From: Laura Gibbons [REDACTED]
Sent: 03 August 2021 15:54
To: Michael Eastham <Michael.Eastham@arun.gov.uk>
Cc: Planning.Responses <Planning.Responses@arun.gov.uk>
Subject: Re: FW: Planning Consultation on: LU/184/21/DOC

Thanks for sending over the additional information. I have the following comments regarding conditions 10 and 12:

Application No: LU/184/21/DOC

Site Address: Phase 2B Hampton Park Toddington Lane Littlehampton BN17 7PL

WEST OF WEILANDS CATCHMENT - WATERCOURSES/HEADWALL AFFECTED

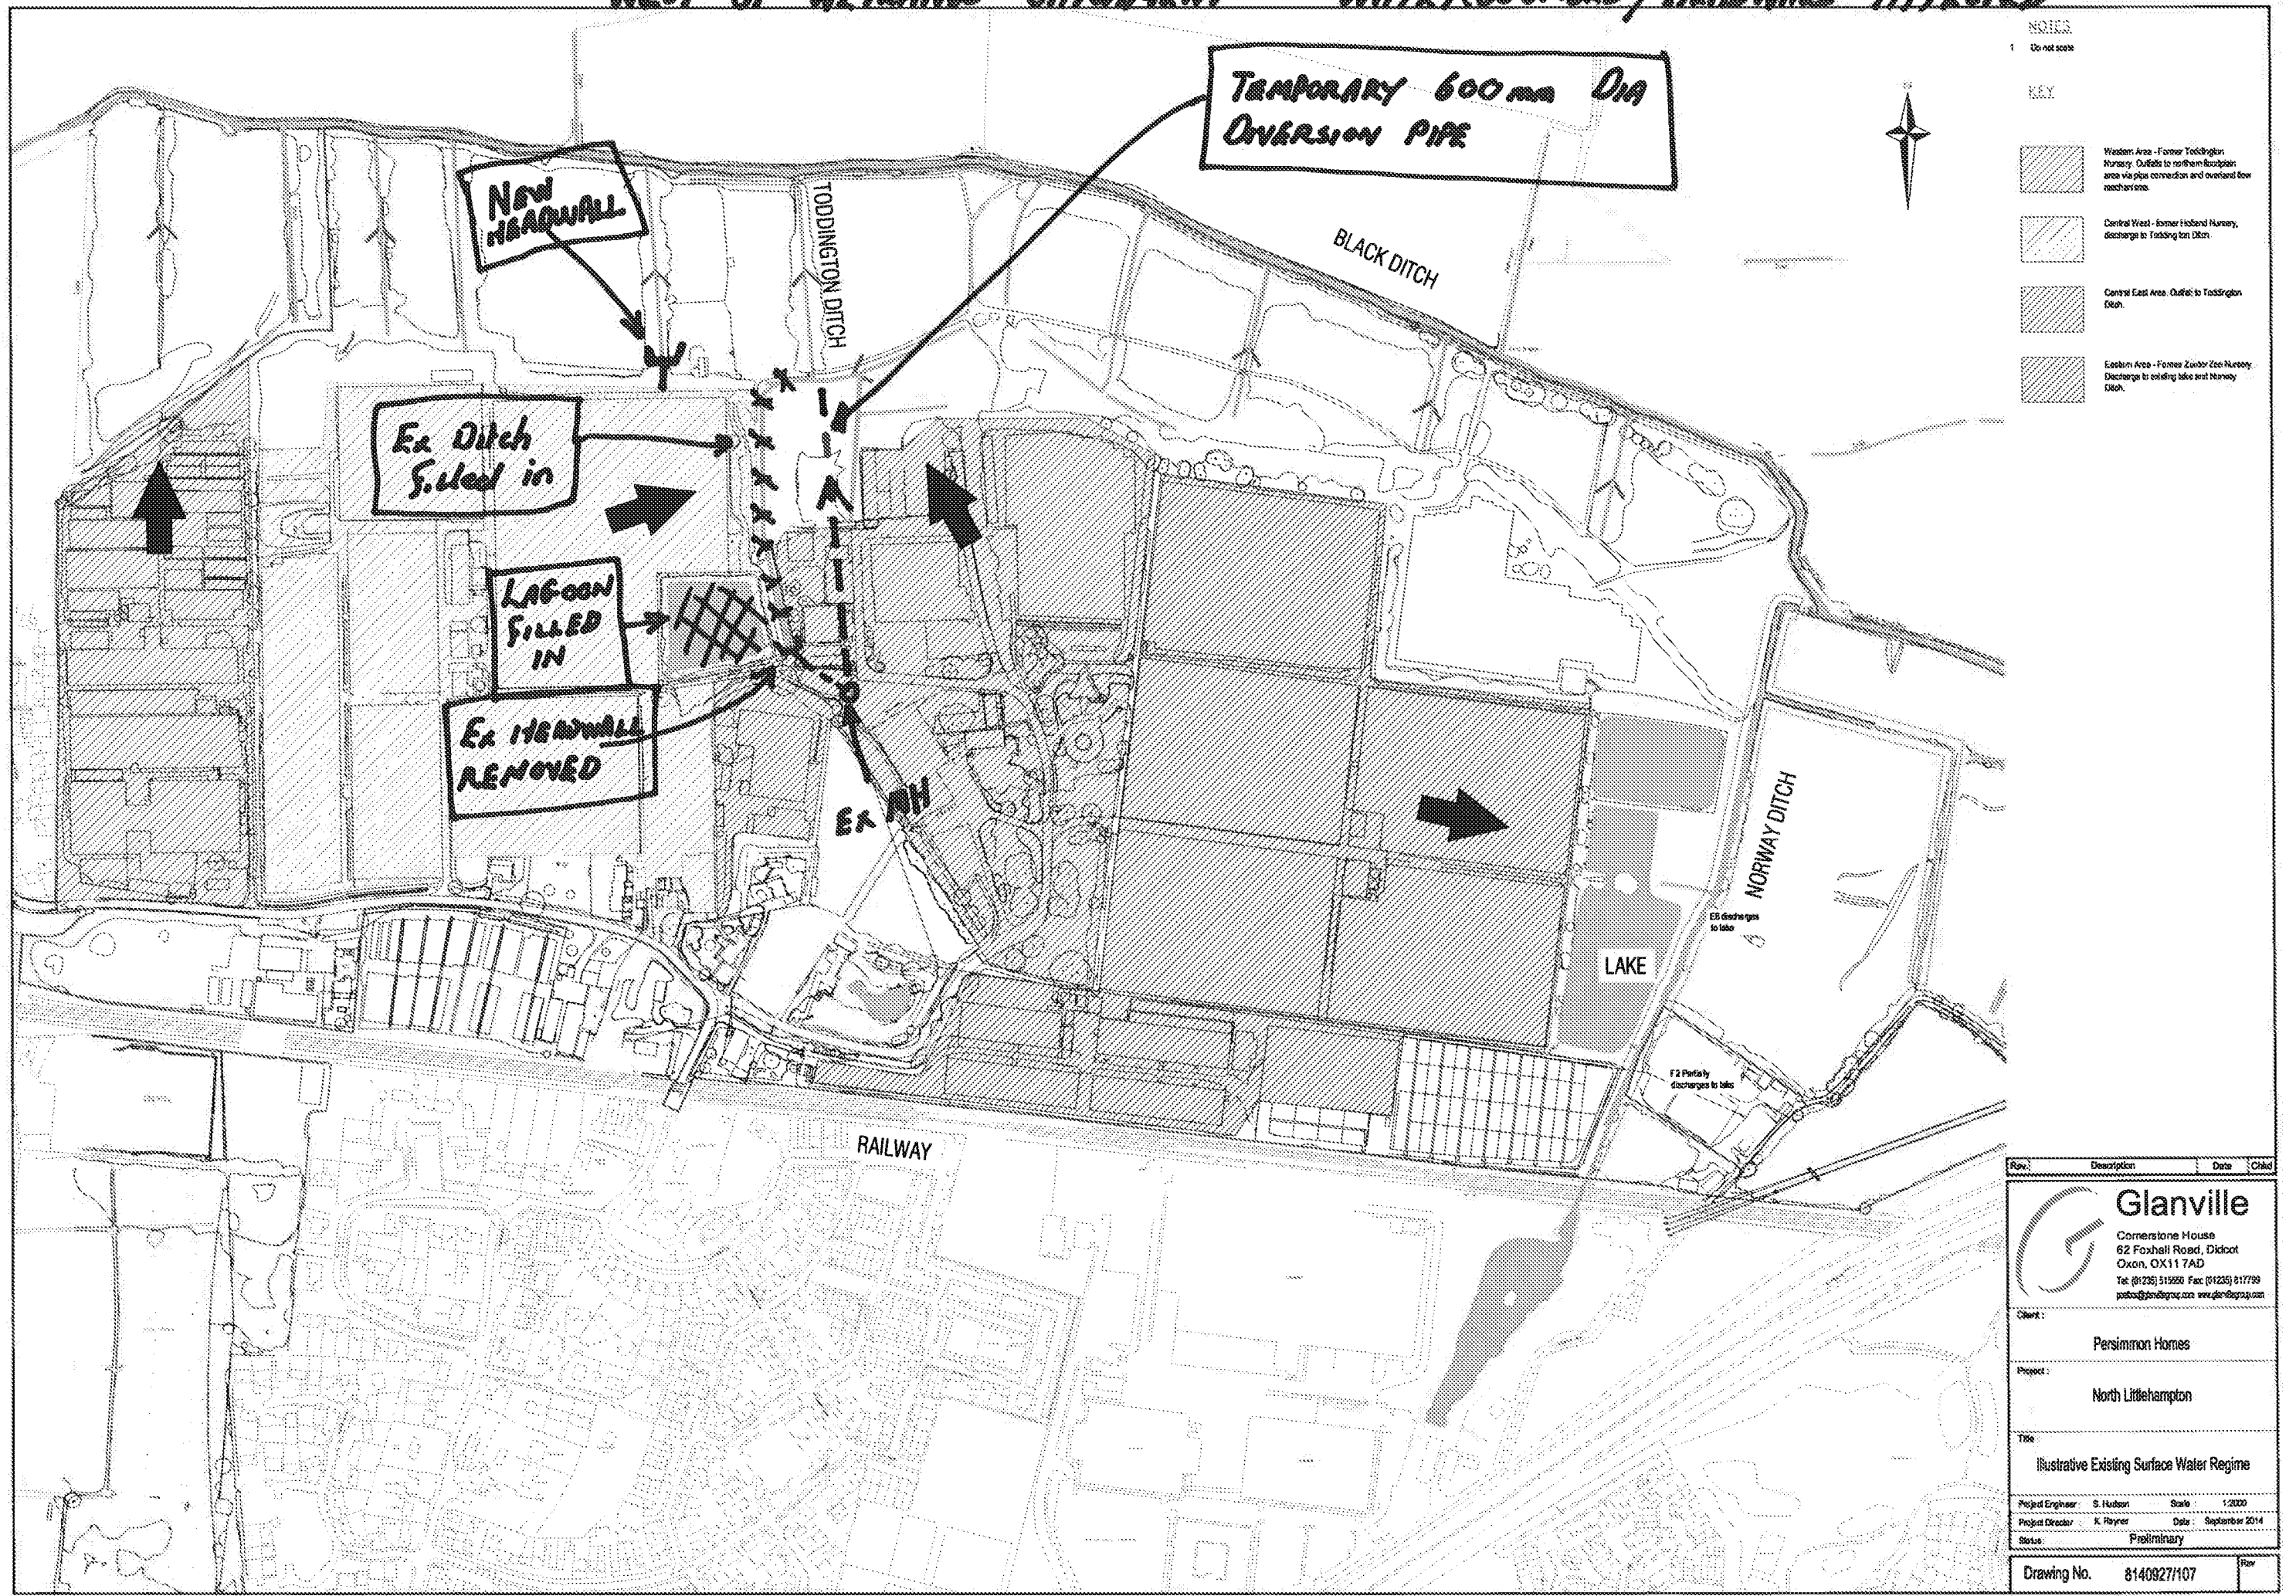
As phase 2 is reliant upon the new ditch and culverts within the central wetland area being in place we do require details of these at this stage. The applicant should also confirm if the proposals for a new ditch and culverts have the required consent, and supply evidence of this.
